Please see attached our comments on planning case H23-0201-26.

Our ref: 26_34832_P

Your ref: H23-0201-26

Site Location: Former Telephone Exchange,
Common Road, Whaplode Drove, Spalding, PE12
0UF

Proposed Block Plan  
Scale 1:100

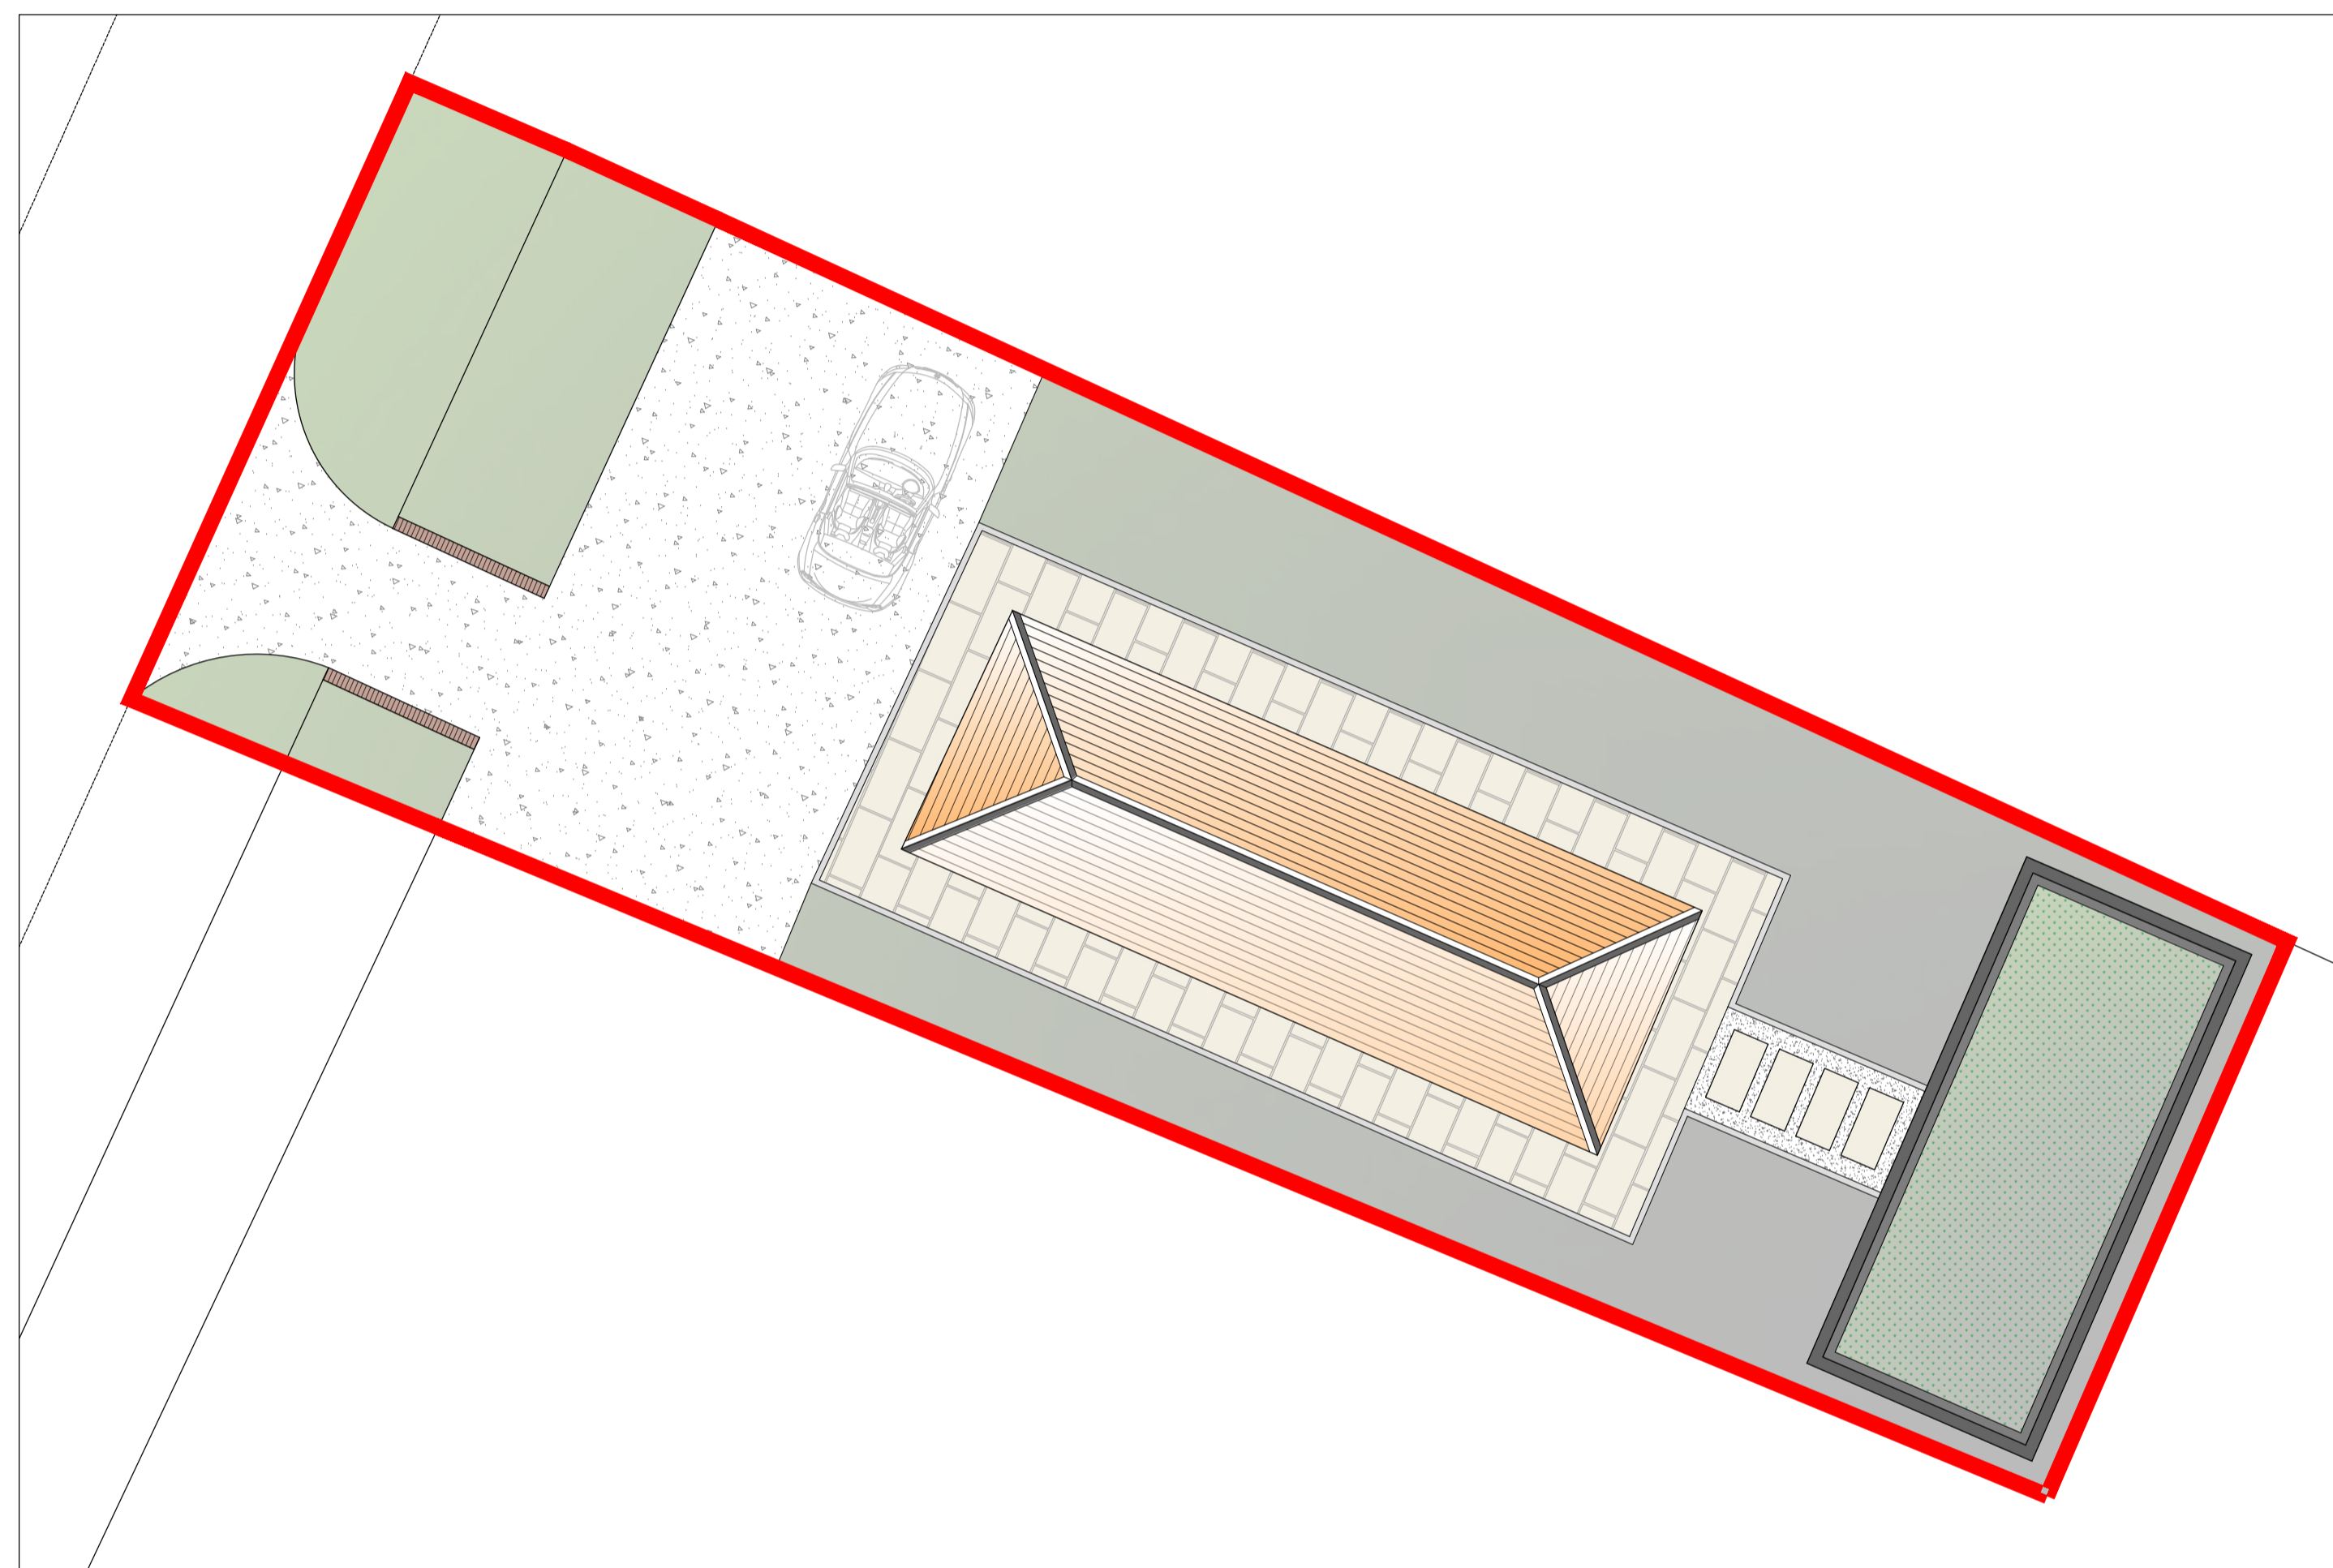
We note the presence of watercourses which are not maintained by the Board (riparian watercourses) adjacent to the northern and western site boundaries. Whilst it has not been explicitly stated within the drawing, the Proposed Block Plan (0534/26/02, JC Architectural Consultant, 24/02/2026), suggests that the existing site access will be improved to facilitate the proposed development. To enable this proposal consent is required under Section 23 of the Land Drainage Act 1991 (and byelaw 4) and I recommend that the applicant contacts this office to make an application for this consent at their earliest convenience.
